ACCESS COMPLIANCE ASSESSMENT REPORT

PROJECT:	64–66 Lavender Street and 3–7 Middlemiss Street, Lavender Bay
REF. No.:	NEW250951 (Rev 2)
DATE:	21/04/2026
CLIENT:	Central Element
CONTACT:	Hugh Roberts
EMAIL:	hroberts@ centralelement.com.au
CONSULTANT:	Mauricio Vera
PHONE No:	0451 078 790
EMAIL	mvera@newcrown.com.au

The evolving design documentation submitted at this stage of the design is detailed to the extent where the preparation of a comprehensive assessment report is achievable. This report is a final version for State Significant Development Application (SSDA) Stage.

LAVENDER BAY
3-7 Middlemiss St
64-66 Lavender St
Drawing Name
FLOOR PLAN - BASEMENT 04

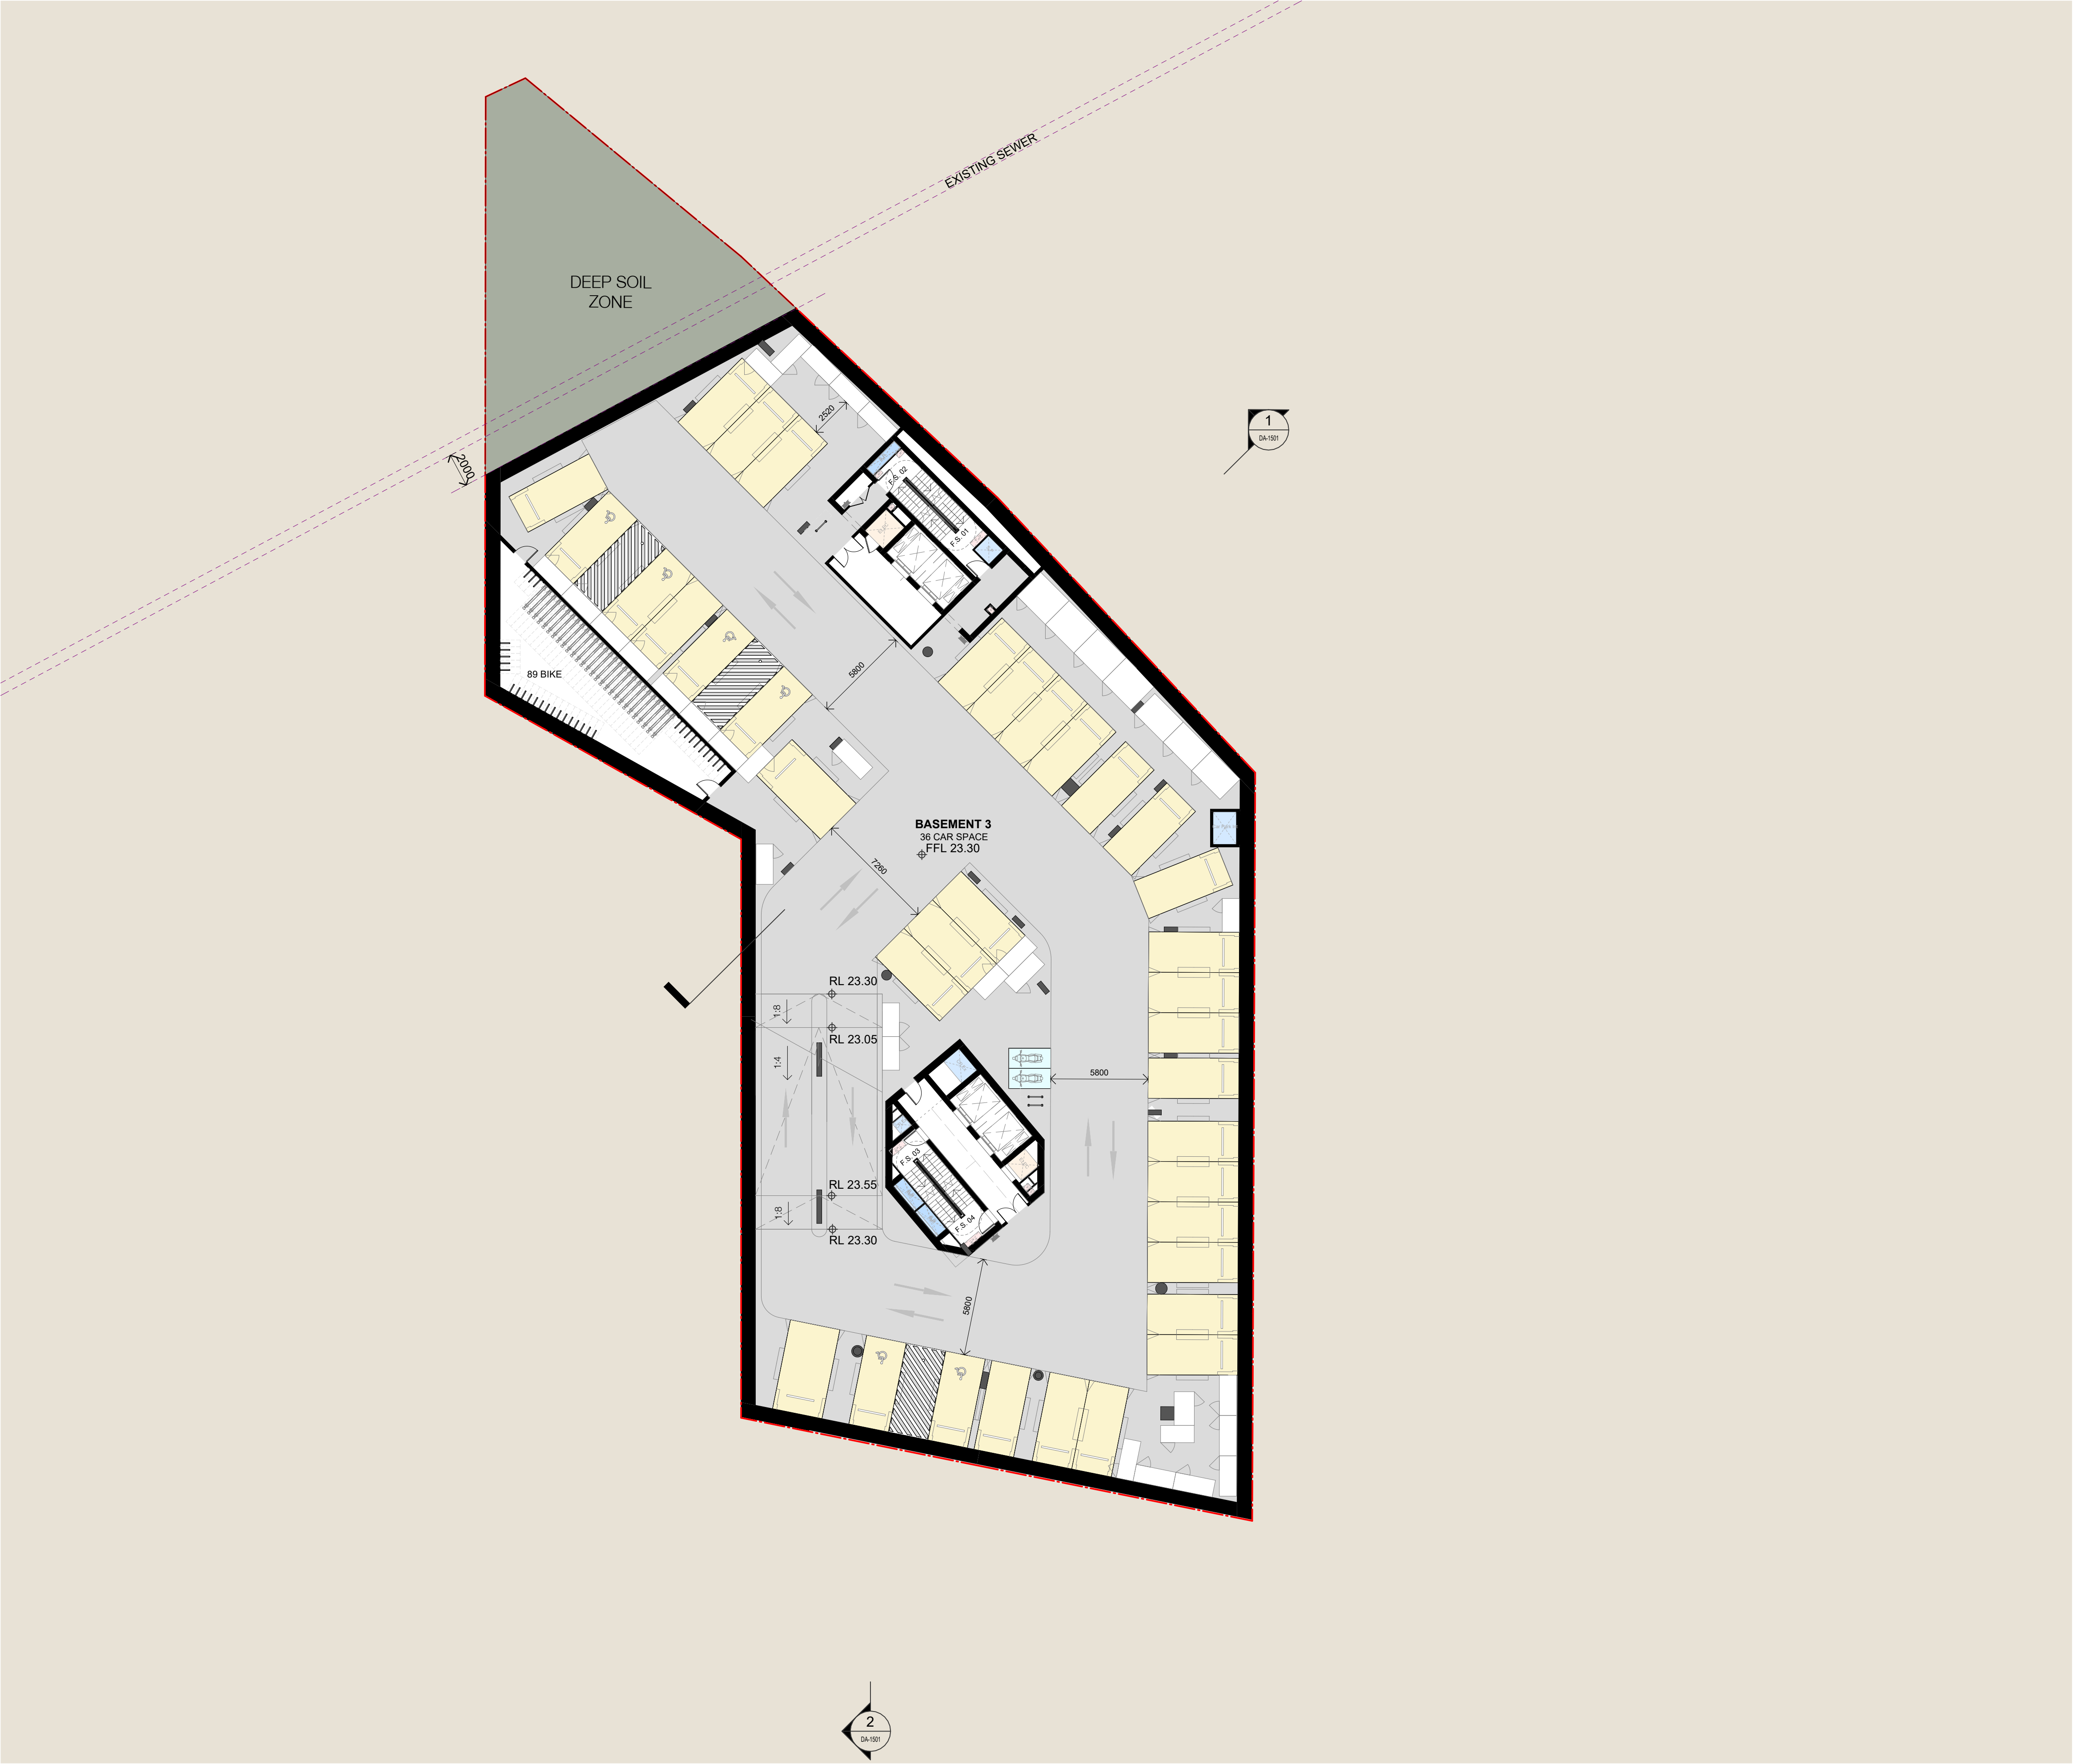
- Insufficient walkway clear width of circa 800mm in lieu of 1000mm minimum serving the middle storage units at basement 05 to 02, in non-compliance with this clause and AS1428.1. To be rectified.

It is expected this area to be provided with at least 1m width walkway to the storage cage. Alternatively, pursue a Performance Solution if feasible.
